From: Martyn White
Sent: 29 June 2018 13:46
To: Planning.Responses
Cc: Anita Gardner
Subject: LU/76/18/PL

LU/76/18/PL

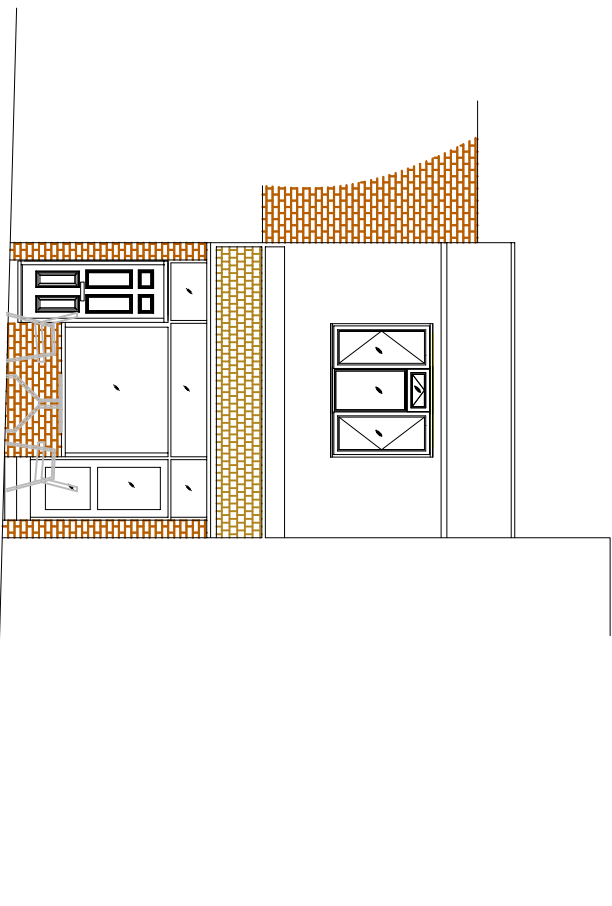
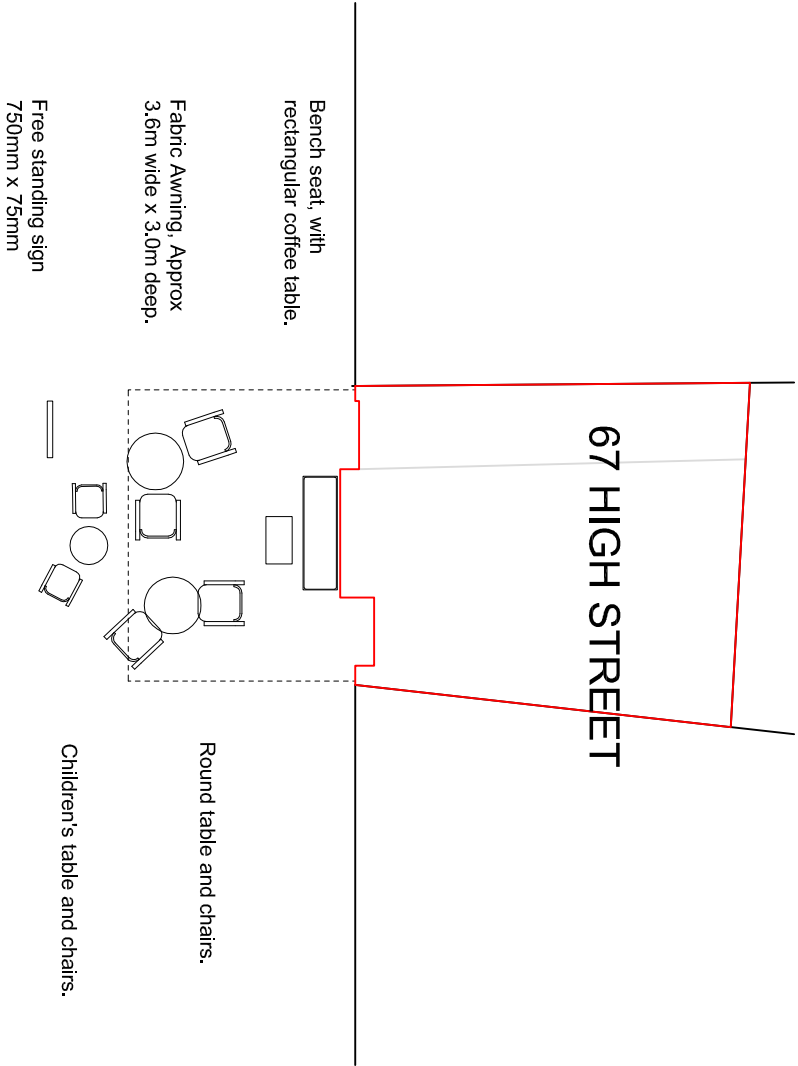
The use of the pavement for outside seating in association with the current use seems to be acceptable, and would have a neutral impact on the setting of the asset. This is partly on the basis that the seating is not fixed and can be removed on a daily basis.

The awning is a more permanent feature on the building, but it is assumed that it will only be extended when needed. This has the potential to reduce that impact that it has upon the neighbouring assets. As a consequence, it is considered to have a neutral impact. When no longer required by an occupant, the awning should be removed from the elevation.
